From: [Borough Planning](#)
To: [Sandra Homcenko](#)
Subject: FW: 21/00094/F 14 Golds Pightle, Ringstead, PE36 5LD
Date: 03 February 2021 08:41:03
Attachments:

From: summit architectural <summitarchi@gmail.com>
Sent: 02 February 2021 15:52
To: Borough Planning <borough.planning@West-Norfolk.gov.uk>
Subject: 21/00094/F 14 Golds Pightle, Ringstead, PE36 5LD

Drawing no.
PEA PL1.1

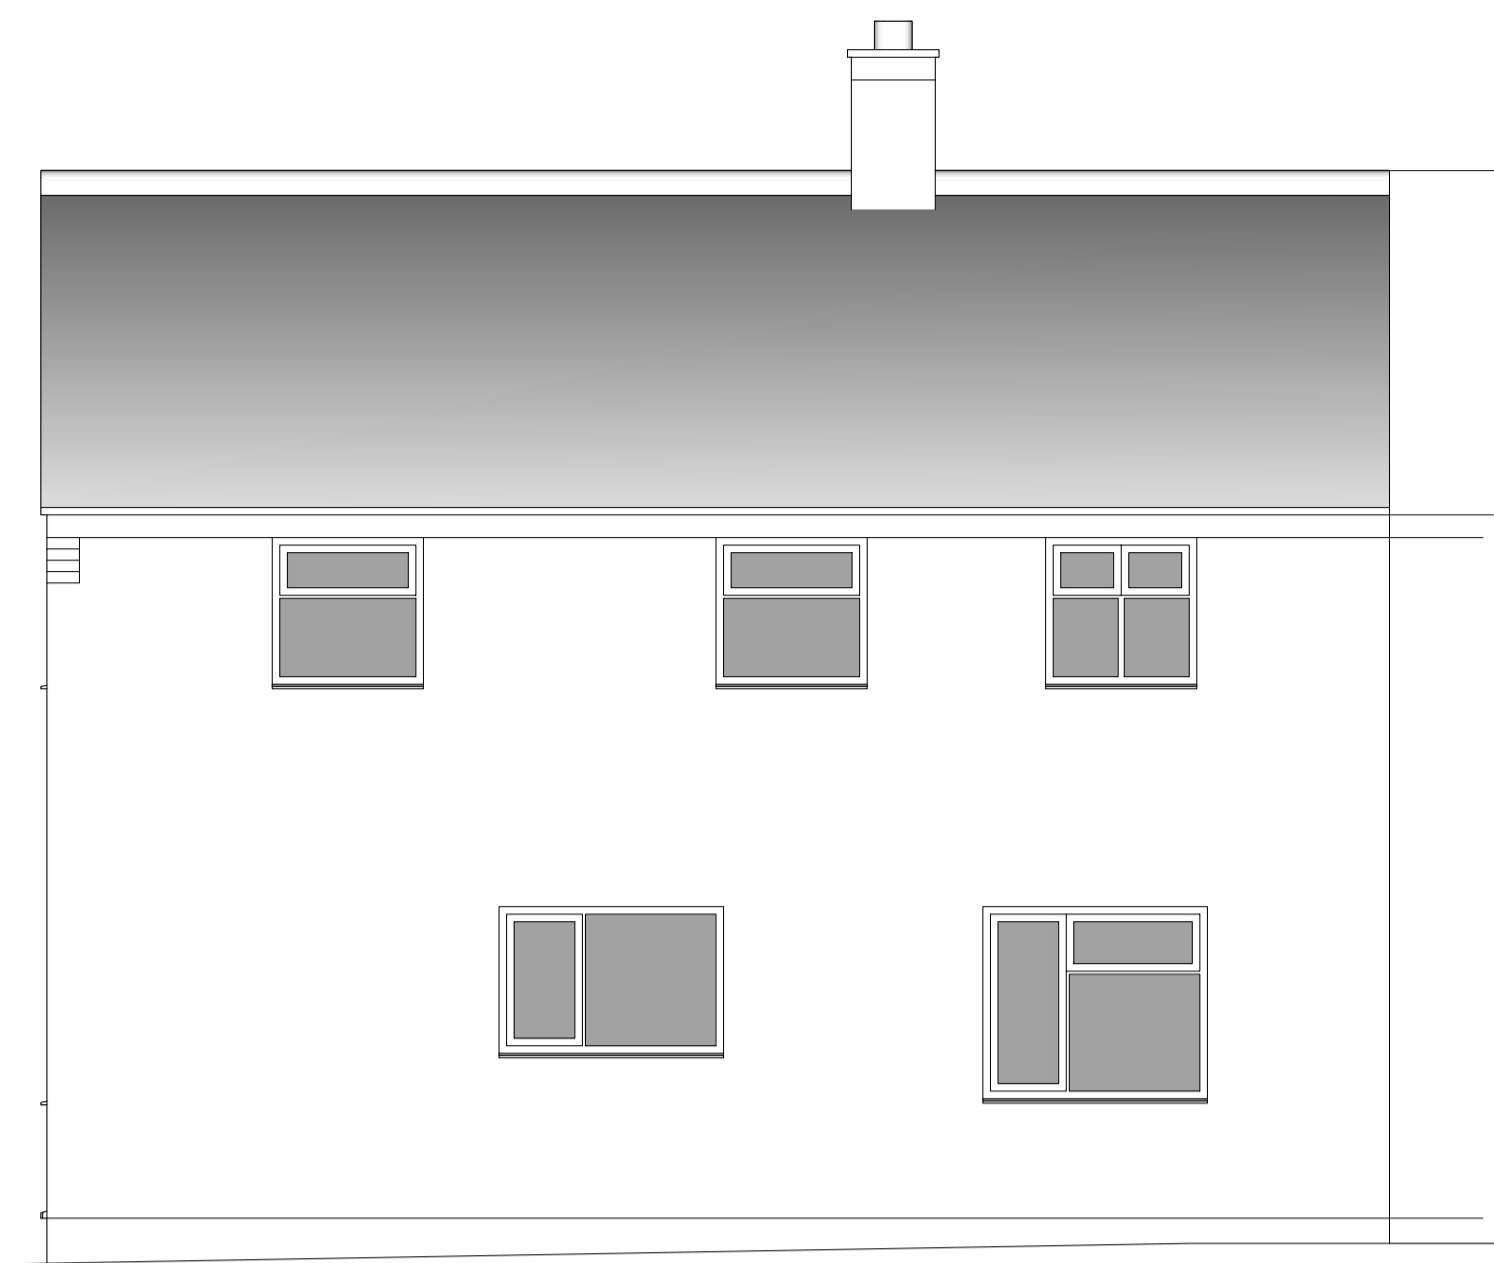
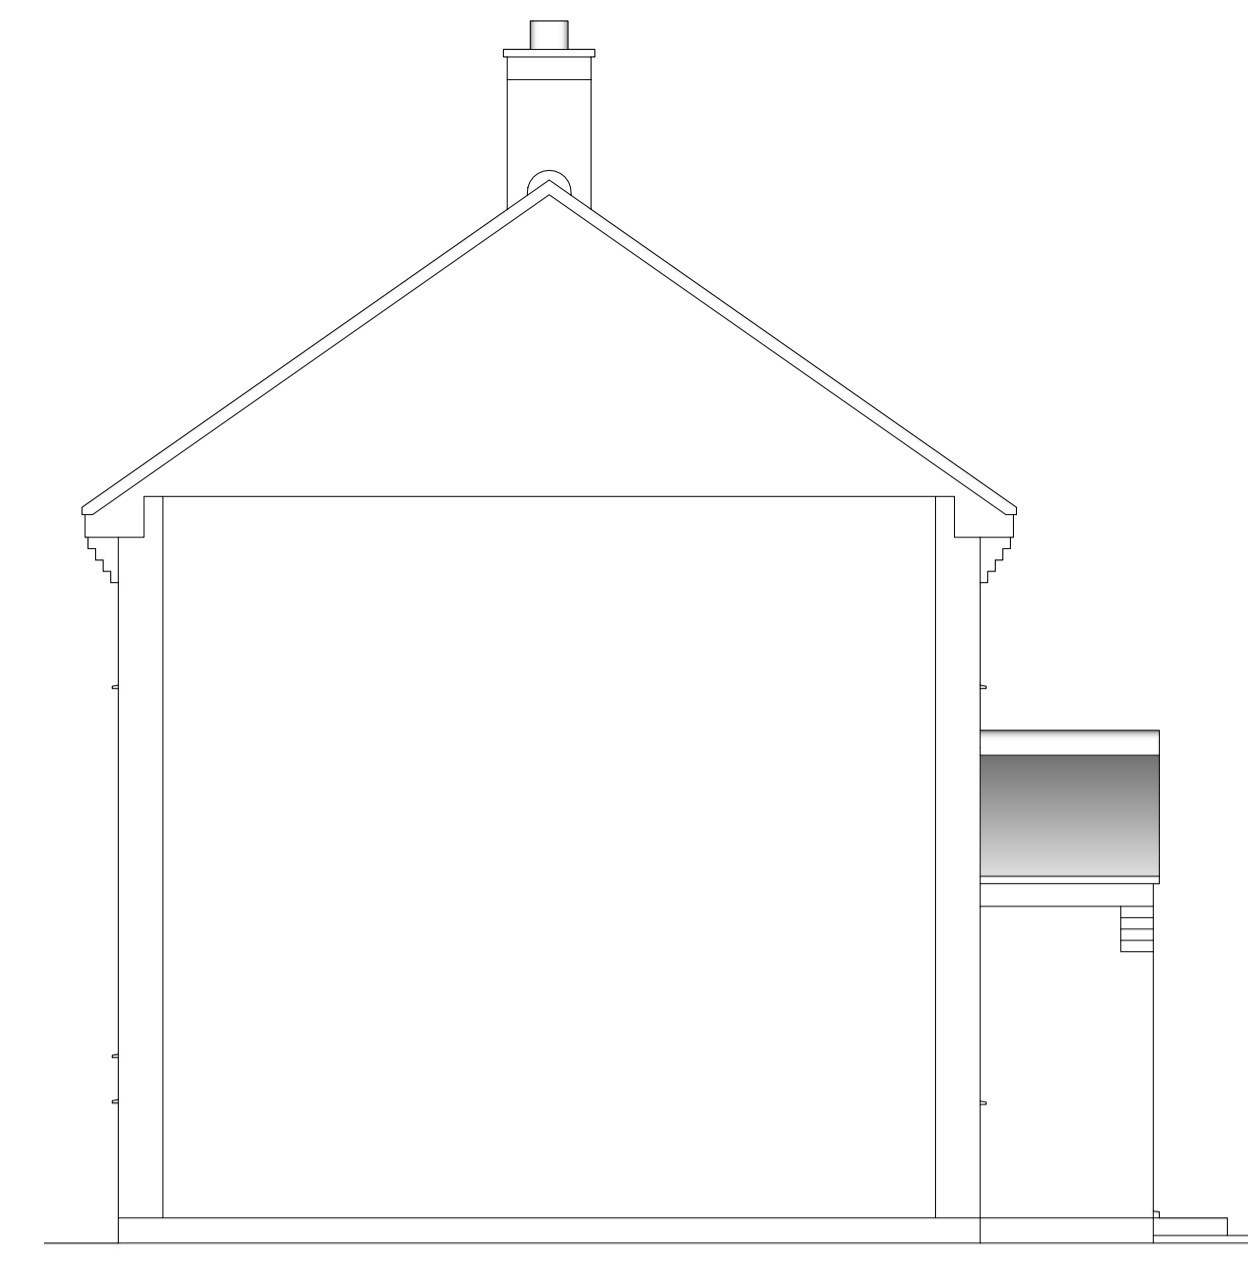
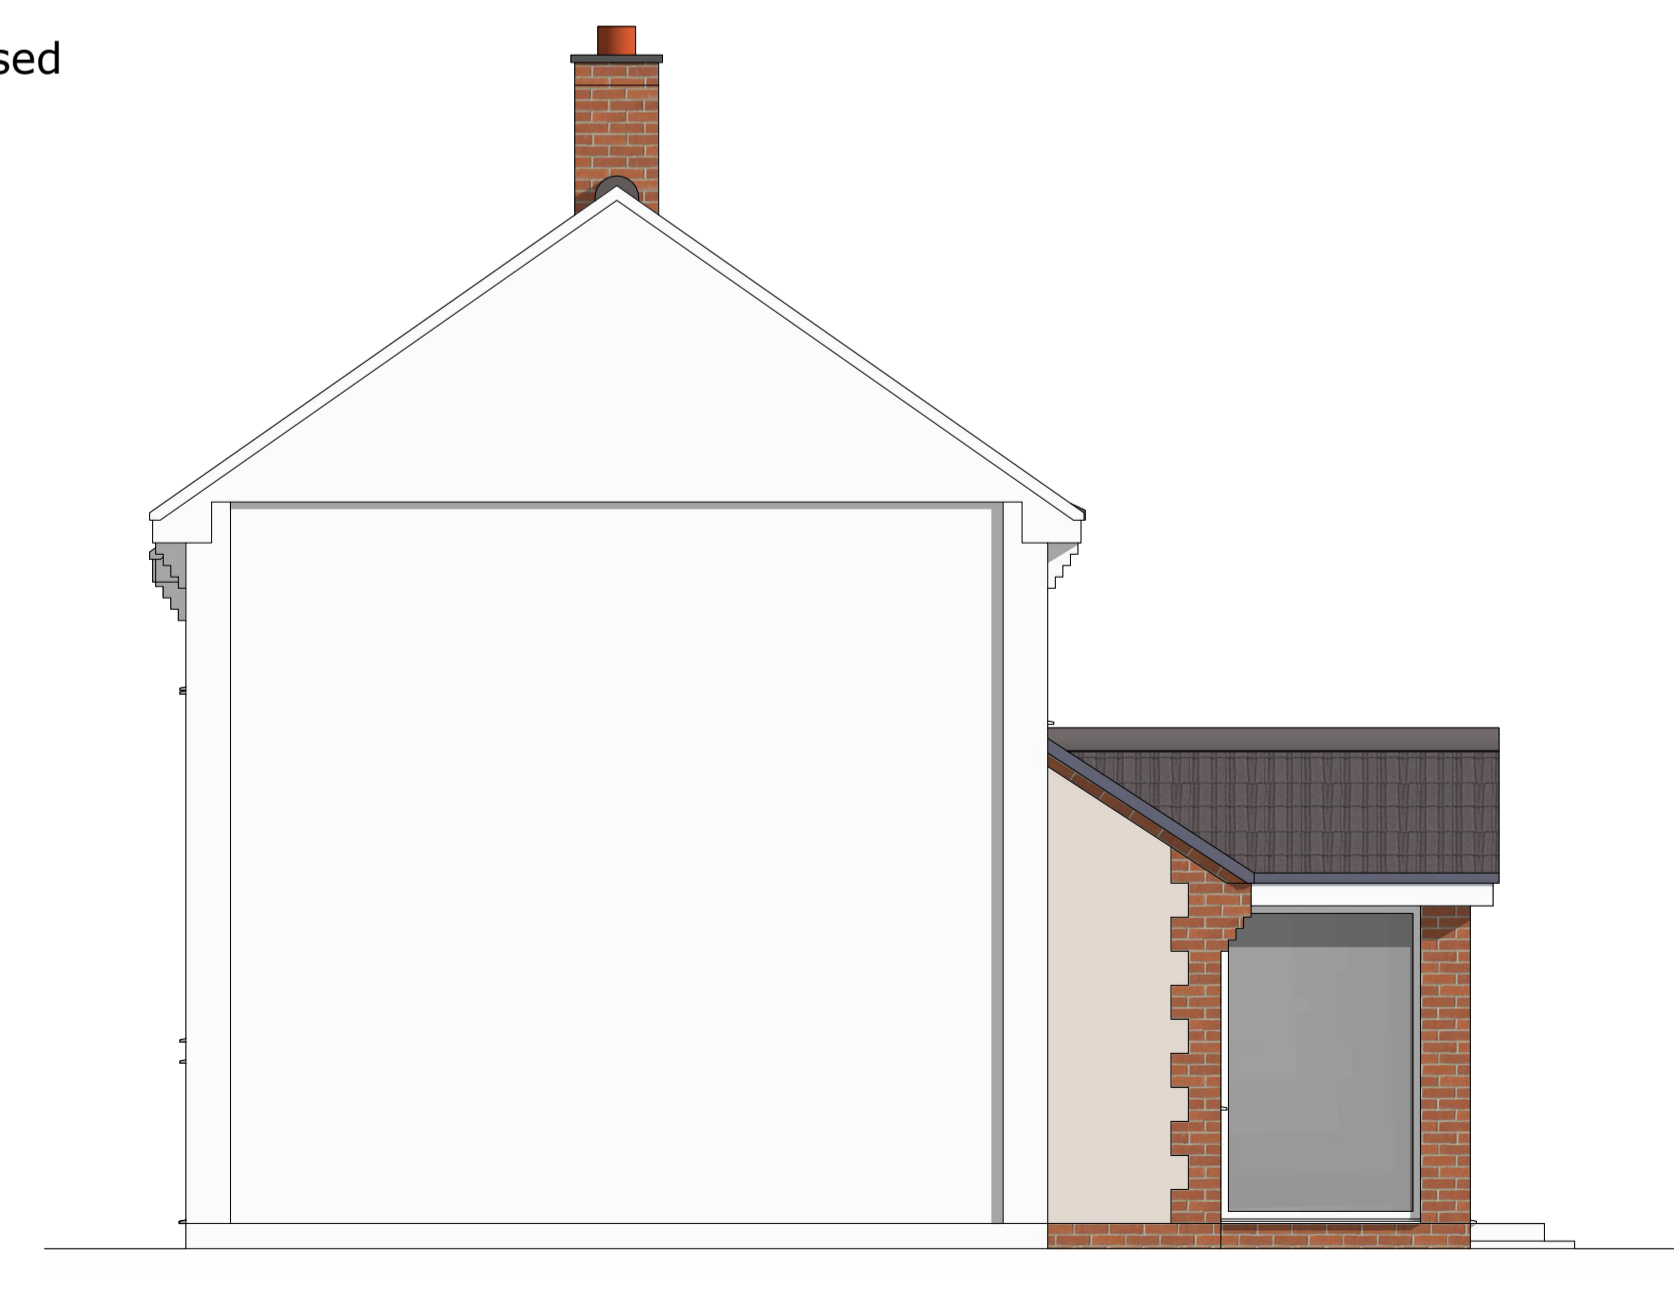
In response to the email 2/2/21 regarding the above application.
I have amended the application on the planning portal, the job description has been altered accordingly and the window has been omitted on the elevation.
